The Member Secretary,
Chennai Metropolitan
Development Authority,
No.1, Gandhi Irwin Road,
CHENNAI -600 008

A1/36455/2001

**Planning Permission - Construction
of Stilt, GF, FF and Second floor part with
3 dwelling units Residential building at
plot No.7, D.No.6A, Gill Nagar, in T.S.No.
76/3, Block No.15, of puliyur village -
Development Charges and other charges to
be remitted - Reg.**

SECOND FLOOR PLAN

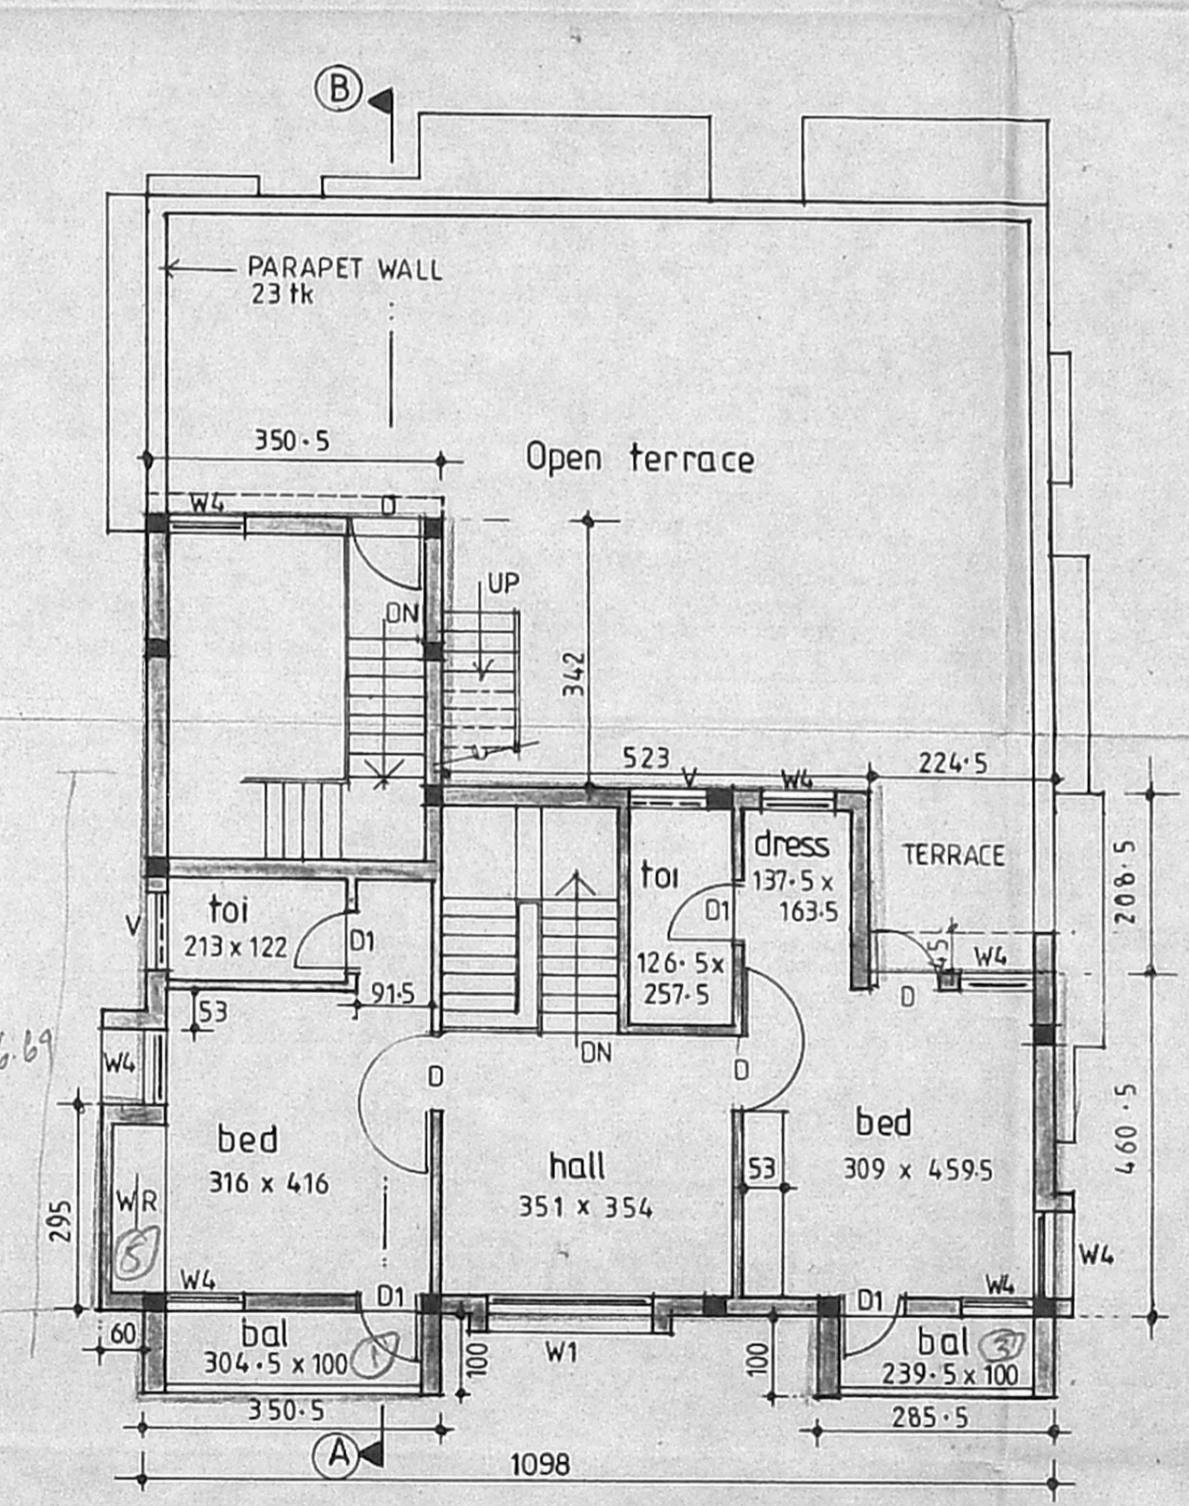
- a) Rain water conservation regulations stipulated by CMDA should be adhered to strictly.
- b. 6 copies of revised plan reducing the flat area in second floor by one sq.m.
